From: Brenda Larsen
Sent: Friday, August 30, 2013 8:05 AM
To: Jeff Watson
Subject: RE: BL-13-00021 Evergreen Valley

Re: Evergreen Valley (BL-13-00021)

BOUNDARY LINE ADJUSTMENT EXHIBIT
KITTITAS CO. TAX PARCEL NUMBERS 822534, 957661 & 15628

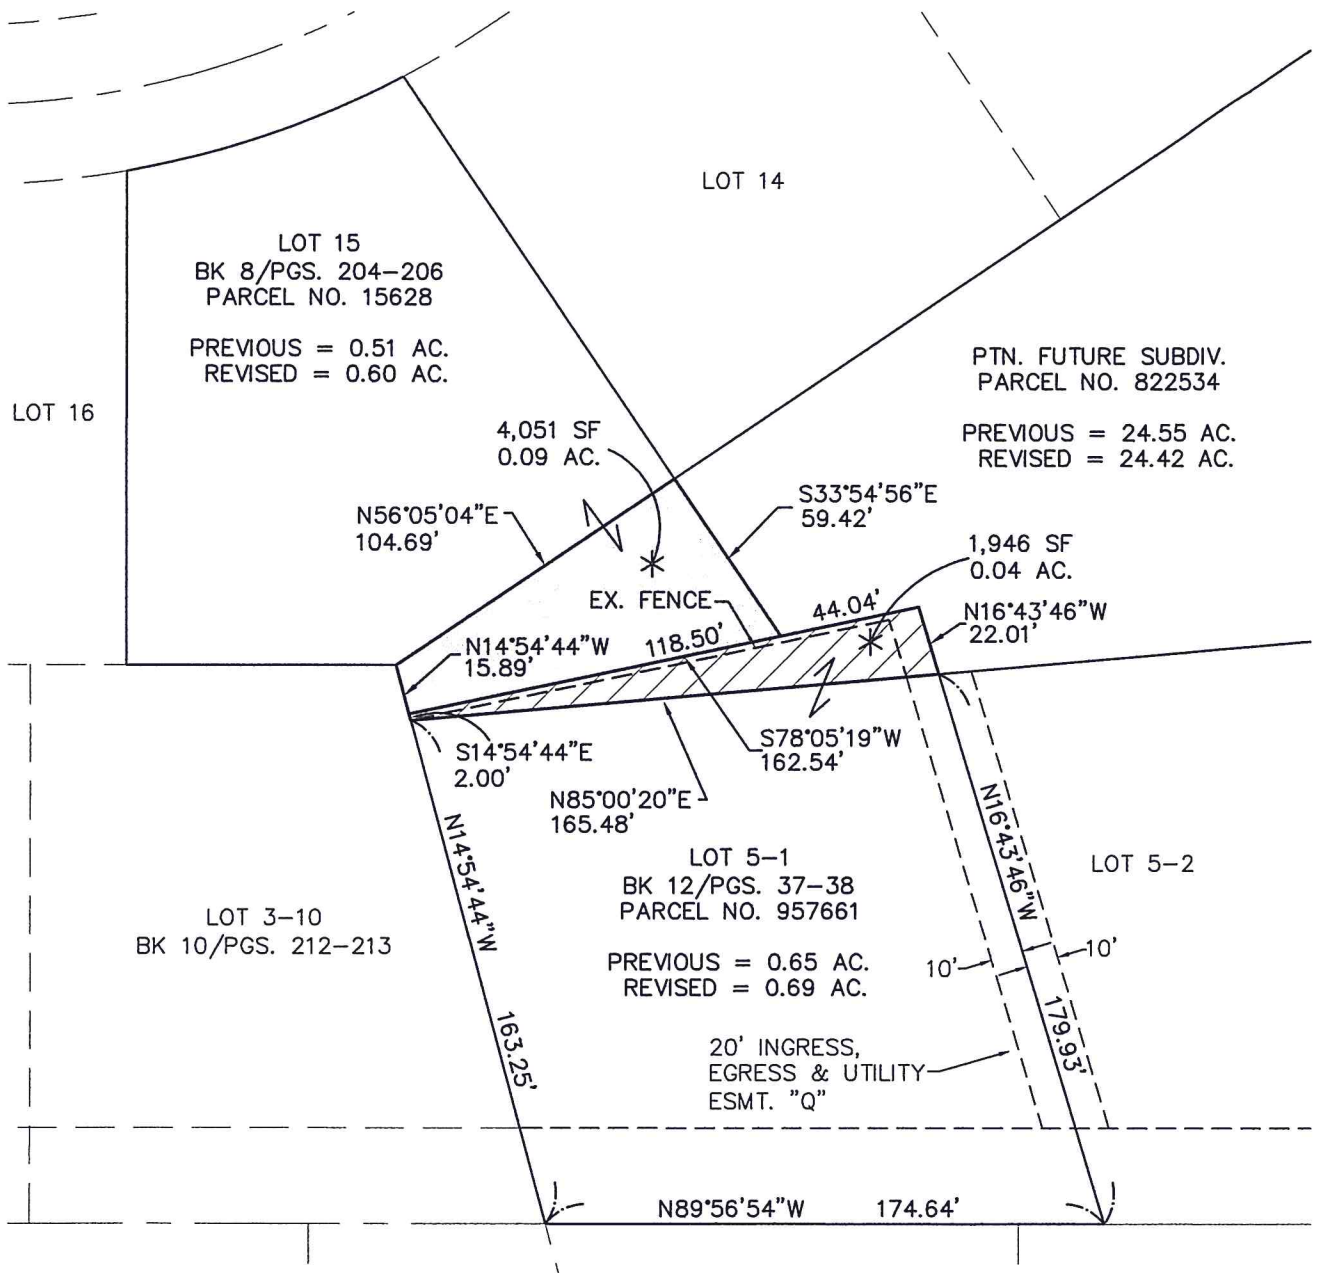
- Ensure that boundary line adjustments do not infringe upon existing structures, to include propane tanks, etc.
- Ensure adequate access for fire apparatus. Any driveways or access points created based off the new lot configurations shall comply with Kittitas County Code 20.02.030.
- All future development must comply with the International Fire Code.
